Response to Planning Application

From: Arun District Council Greenspace

Application ref: WA/106/20/DOC

Description: Approval of details reserved by condition imposed under ref WA/22/15/OUT relating to Condition Nos 6 - materials & finishes, 10 - hard & soft landscaping, 11(a) - protection of retained trees, 12 - surface water drainage, 14 - maintenance & managements of SuDs, 15 - foul drainage and 20(d) - forecourt layout, drainage, position & intensity of lighting fitments.

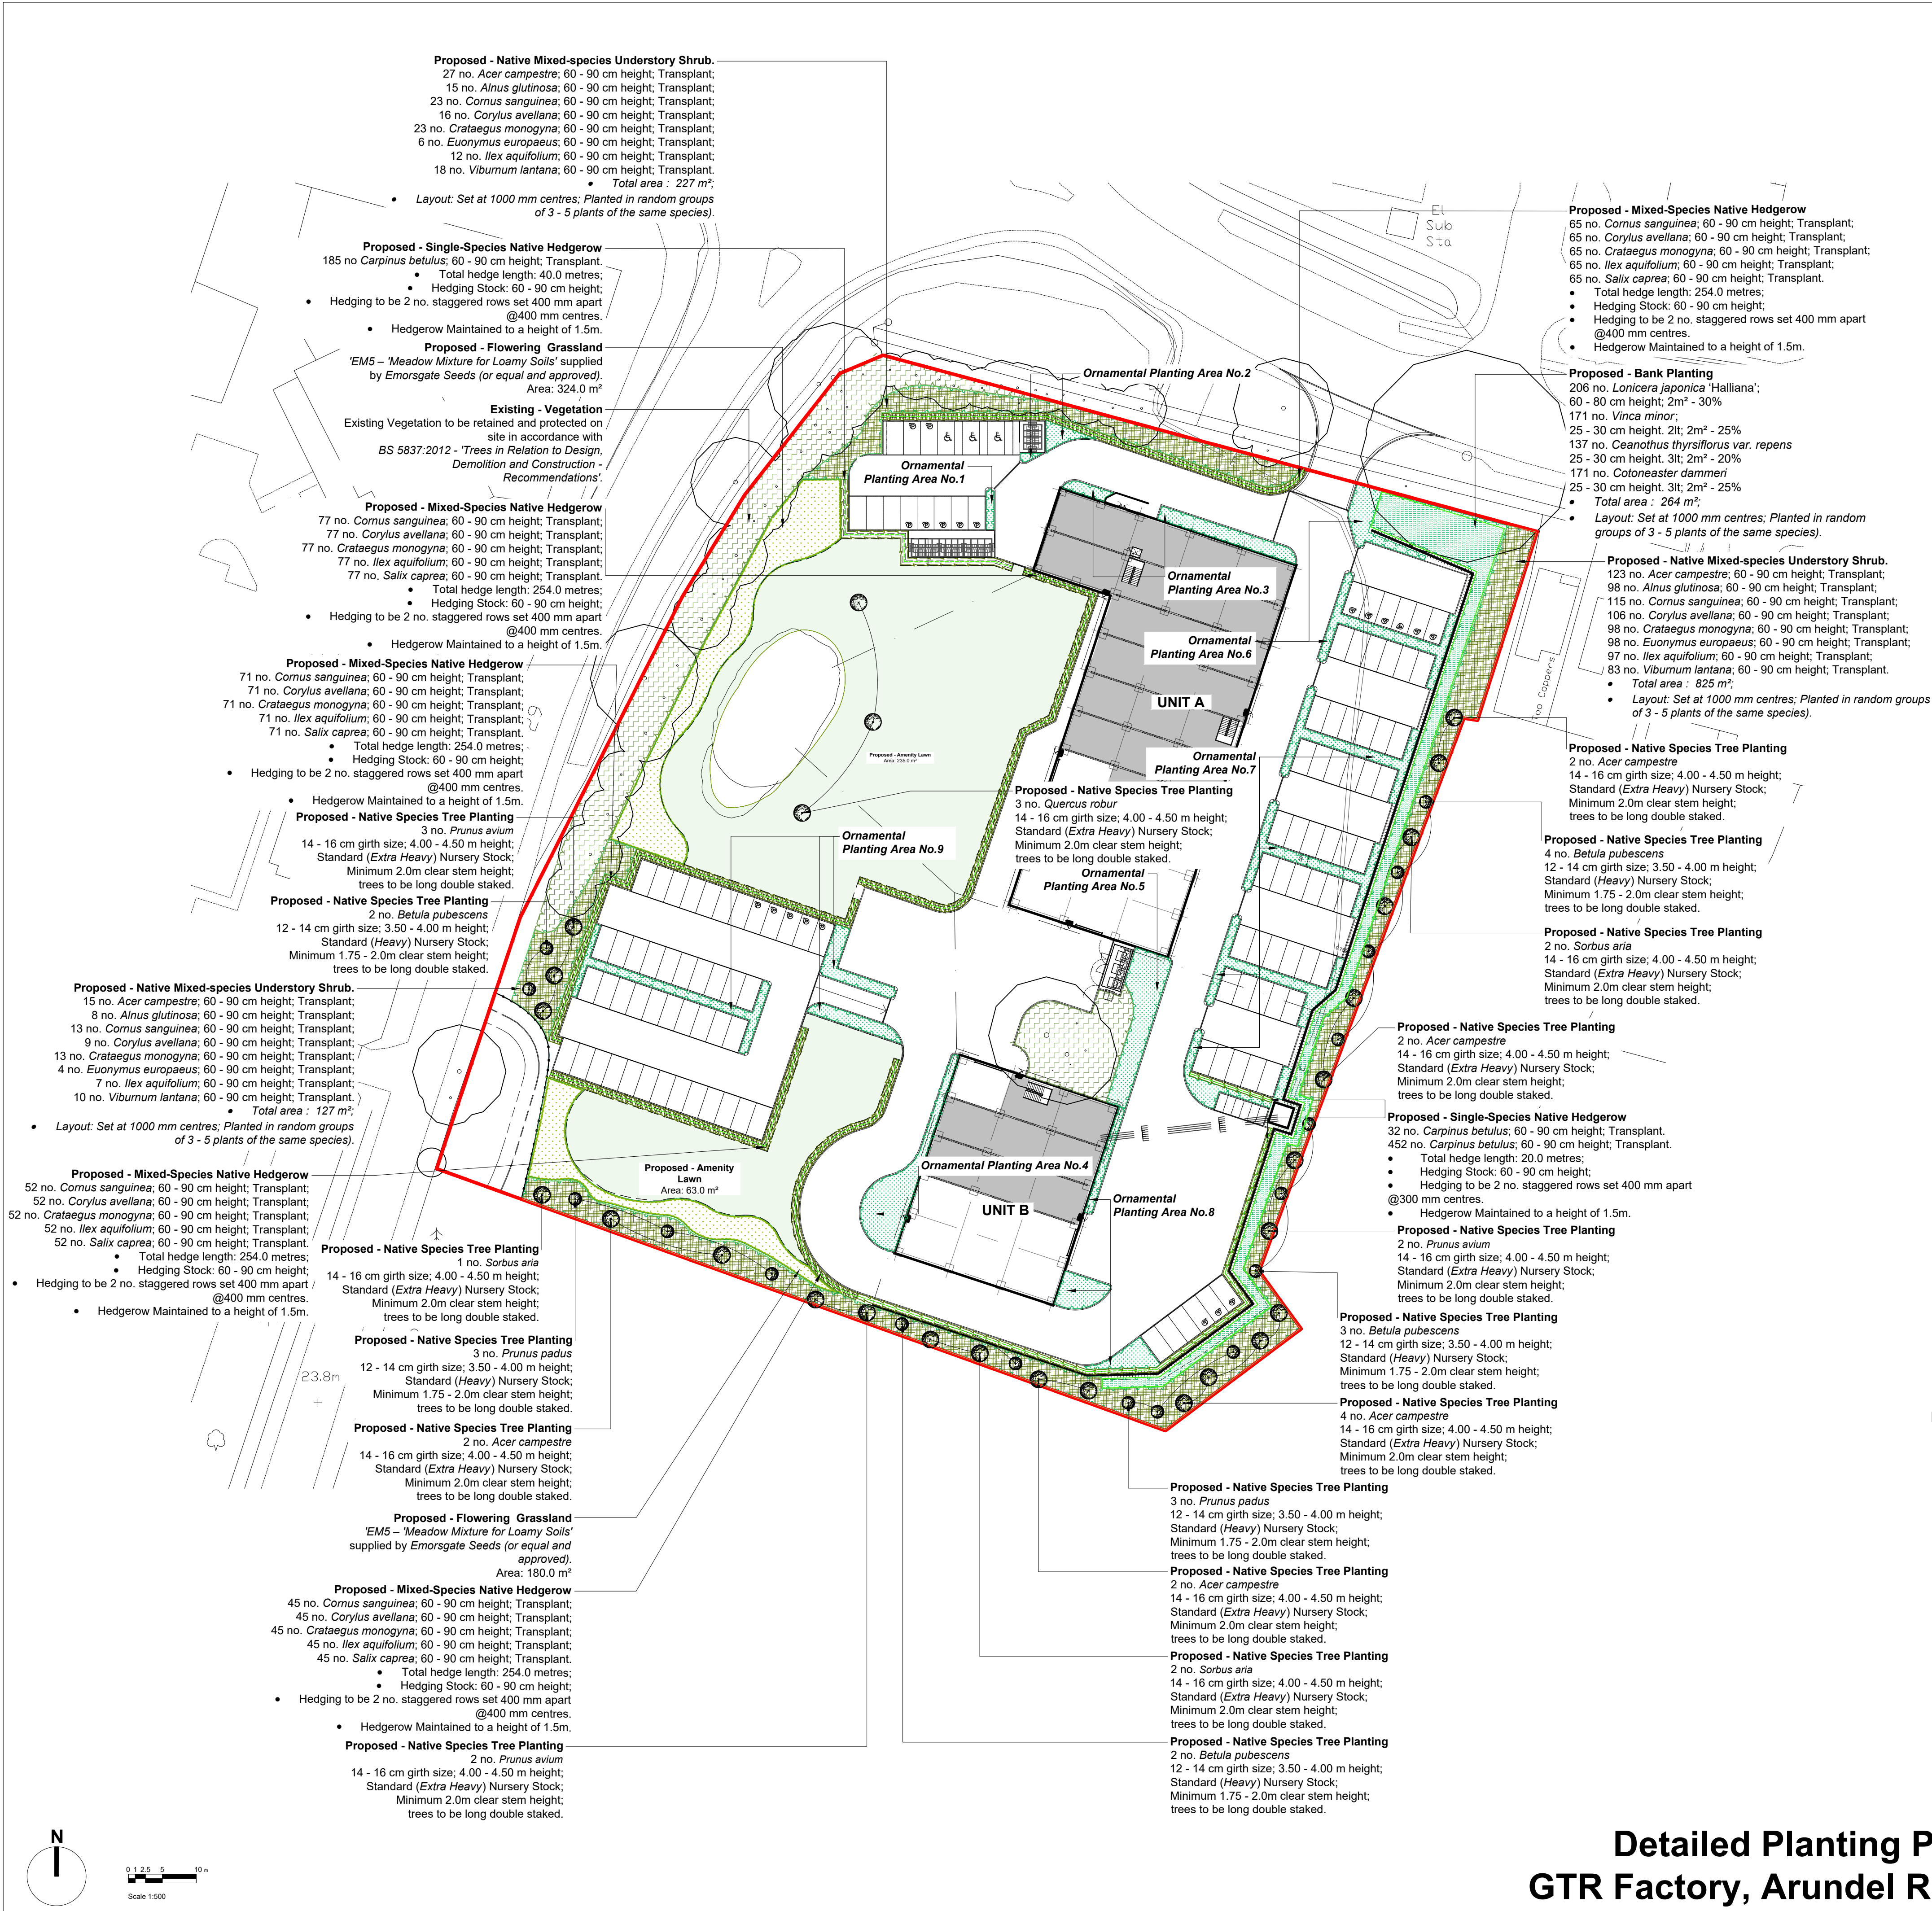
I can confirm that the proposals detail a scheme which would be suitable for location and fitting for this setting. The detail has included a good element of native mixed tree and hedge planting mixes which will aid in biodiversity gain and habitat formation. The scheme has also considered an ornamental element to the planting which would be suitable for the building, carparking and communal surrounds.

Recommend detail to be provided re the attenuation feature which is detailed as to be specified by the drainage engineer. This feature will need to be both functional and fit for purpose, but also in keeping with good design principles for the setting.

The detailed drawings also make reference to the existing mature trees and vegetation to be retained and protected in accordance with BS 5837:2021, It is imperative that these are given the correct protection. In particular is the area to the north/western corner of the site adjoining Fontwell avenue and the roundabout where it appears that the proposed carparking area interfaces with existing established vegetation. Any considered tree works must be in consultation with Arun District Councils Tree Officer and correct tree protection measures in place before construction commences.
